RE: YIRIBANA LOGISTICS ESTATE (YLE) (SSD-10272349)

This submission has been prepared by Mirvac in relation to the Yiribana Logistics Estate (YLE) (SSD-10272349) at 754-770 and 784-786 Mamre Road, Kemps (Lot 59-60 in DP 259135).

This submission is not an objection to the development of the Yiribana Logistics Estate rather provides objection and commentary to several key elements of the proposal as they relate the proposed Mirvac Aspect Industrial Estate (AIE) (SSD-10448) at 788-882 Mamre Road, Kemps Creek NSW 2178 (Lots 54 - 58 in DP 259135).

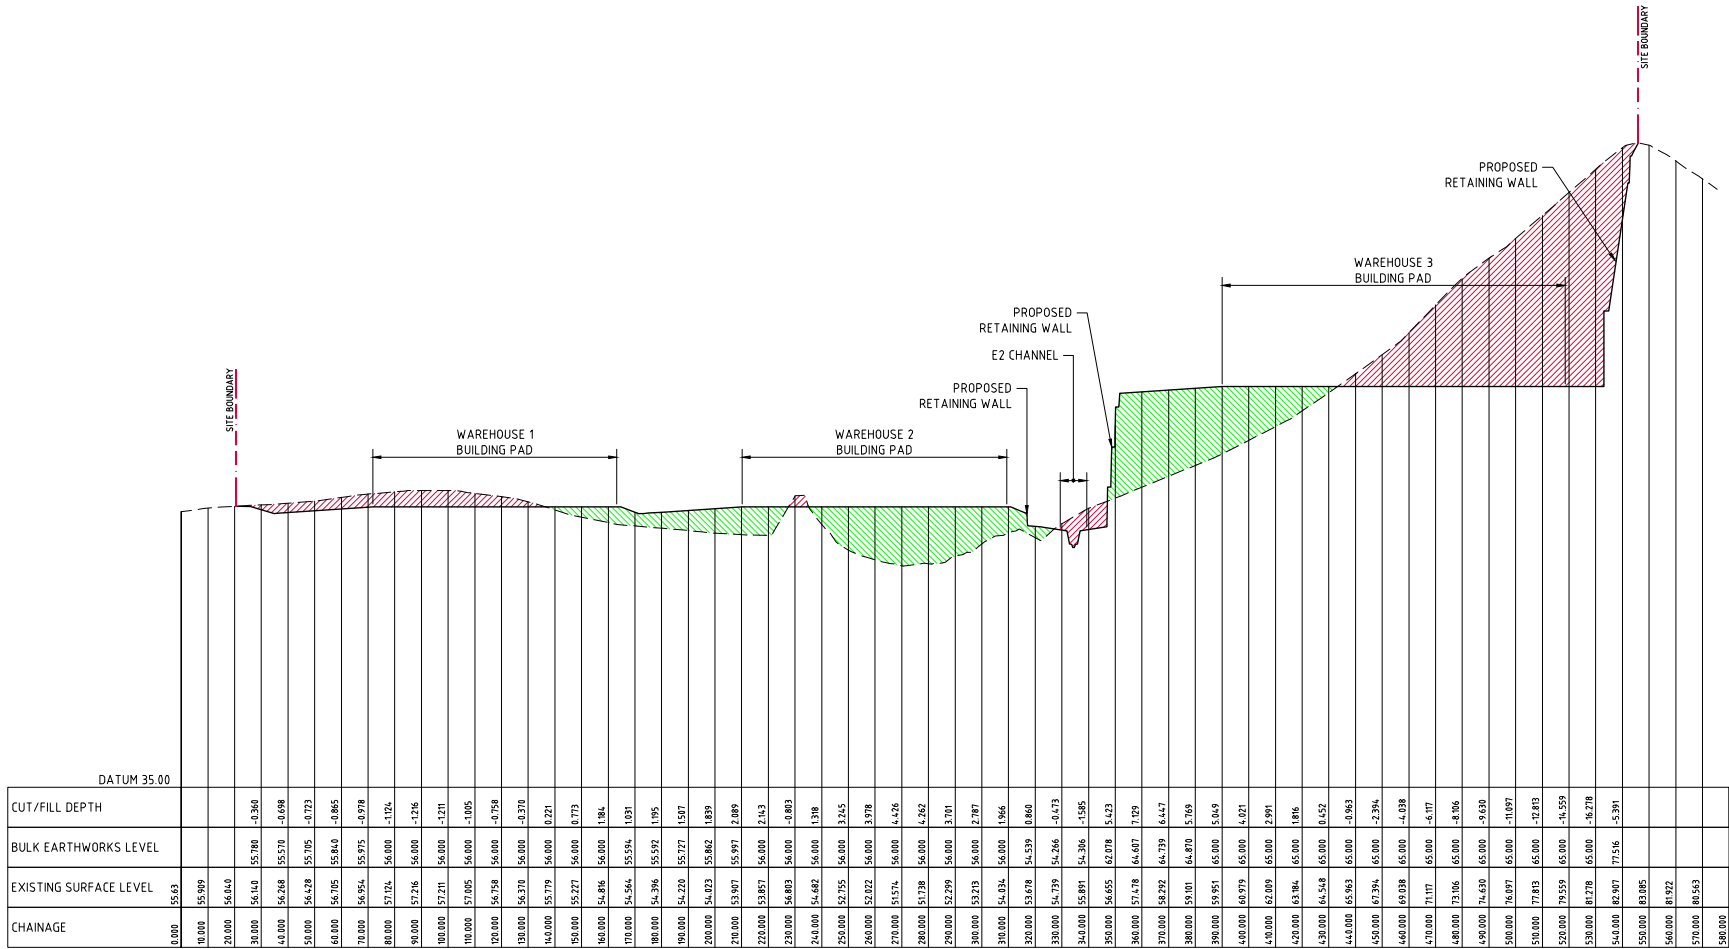
The YLE EIS states the location and indicative heights of retaining walls are provided in the Civil Drawings located within Appendix K. The civil design documentation demonstrates an approximately 11m level difference to the existing levels on the northern boundary of the AIE site but does not propose any retaining wall structure to address this. Rather it seems to seek a temporary batter within the AIE. It is noted that the proposed AIE boundary levels remain unchanged from the Mirvac AIE initial SSD, RTS or subsequent information provided by Mirvac to GPT.

We raise concerns that the GPT proposal does not adequately consider the existing or proposed levels at the boundary. Further, we confirm that Mirvac do not consent to any batters or retaining wall elements (e.g. strap zones) proposed in the YLE being located within the Mirvac site. It is therefore requested that Warehouse No.1 be amended to consider boundary levels as required. Alternatively, we would welcome a meeting with GPT to determine temporary batters into the YLE which could be carried out concurrently or after the AIE works to potentially reduce the required YLE Warehouse No.1 retaining wall extents. Though this would need to be considered and approval sought as part of the YLE SSD.

E2 CORRIDOR ALIGNMENT PLAN
SCALE 1:500

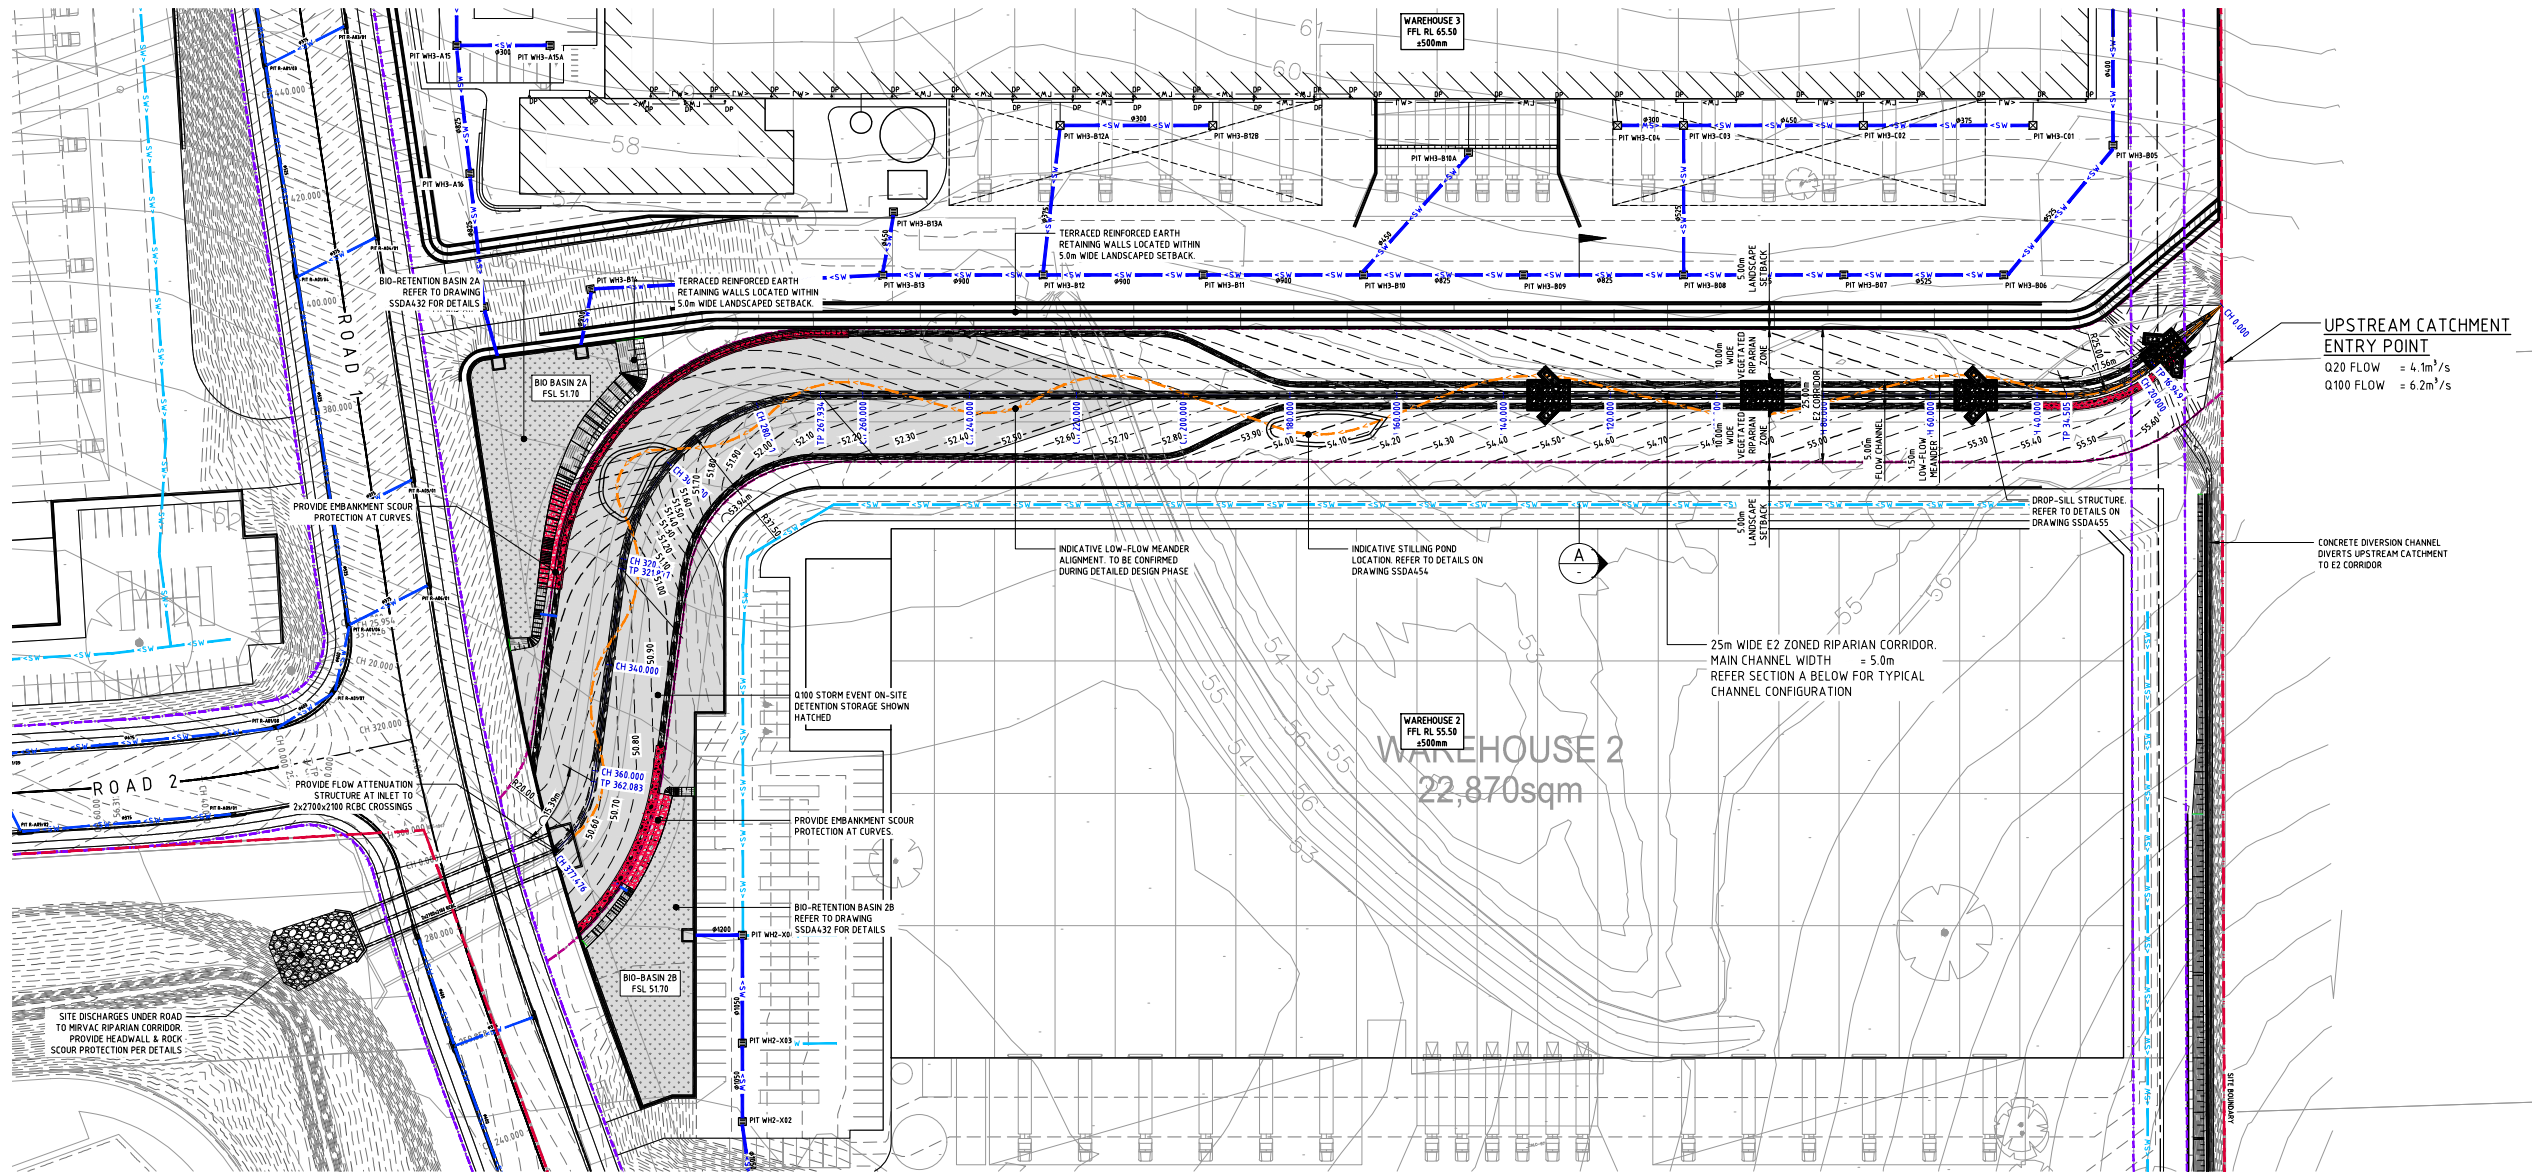
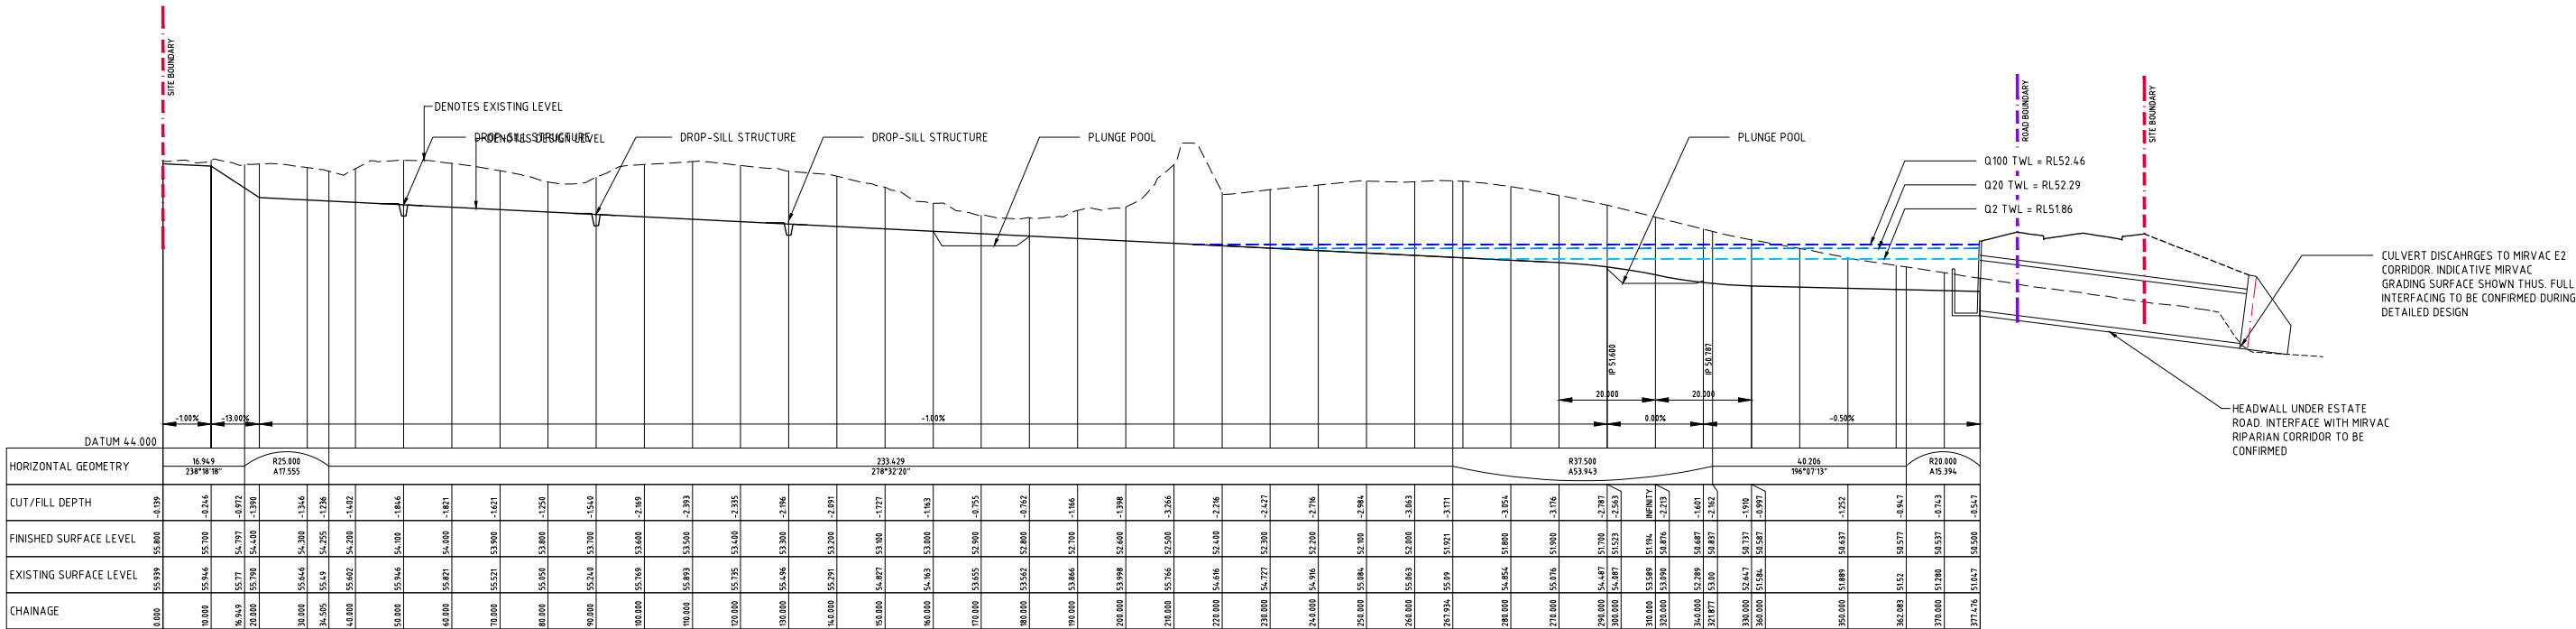
Mirvac support the realignment of the E2 corridor but emphasise the need for co-ordination between the two sites in relation to this item. Of particular importance is ensuring that the proposed structure under the North-South collector road allows for adequate upstream flow conveyance at velocities which do not exceed pre-development conditions. The location and details of this structure is subject to YLE approvals for E2 widths and alignments.

Mirvac does not support to the design of the E2 North-South road crossing as currently documented as part of the YLE SSD. Our concerns relate to the apparent concentration of flows and resultant increased velocities entering the AIE E2 corridor as shown within the submitted EIS Appendix NN. Should energy dissipation be required as result of the YLE E2 corridor realignment, this should be completed within the YLE estate. We believe that this E2 road crossing may be better accommodated via a bridge structure which could be considered as part of the YLE SSD, included within the Mamre Road Precinct local contributions plan and delivered as part of the North-South collector road.
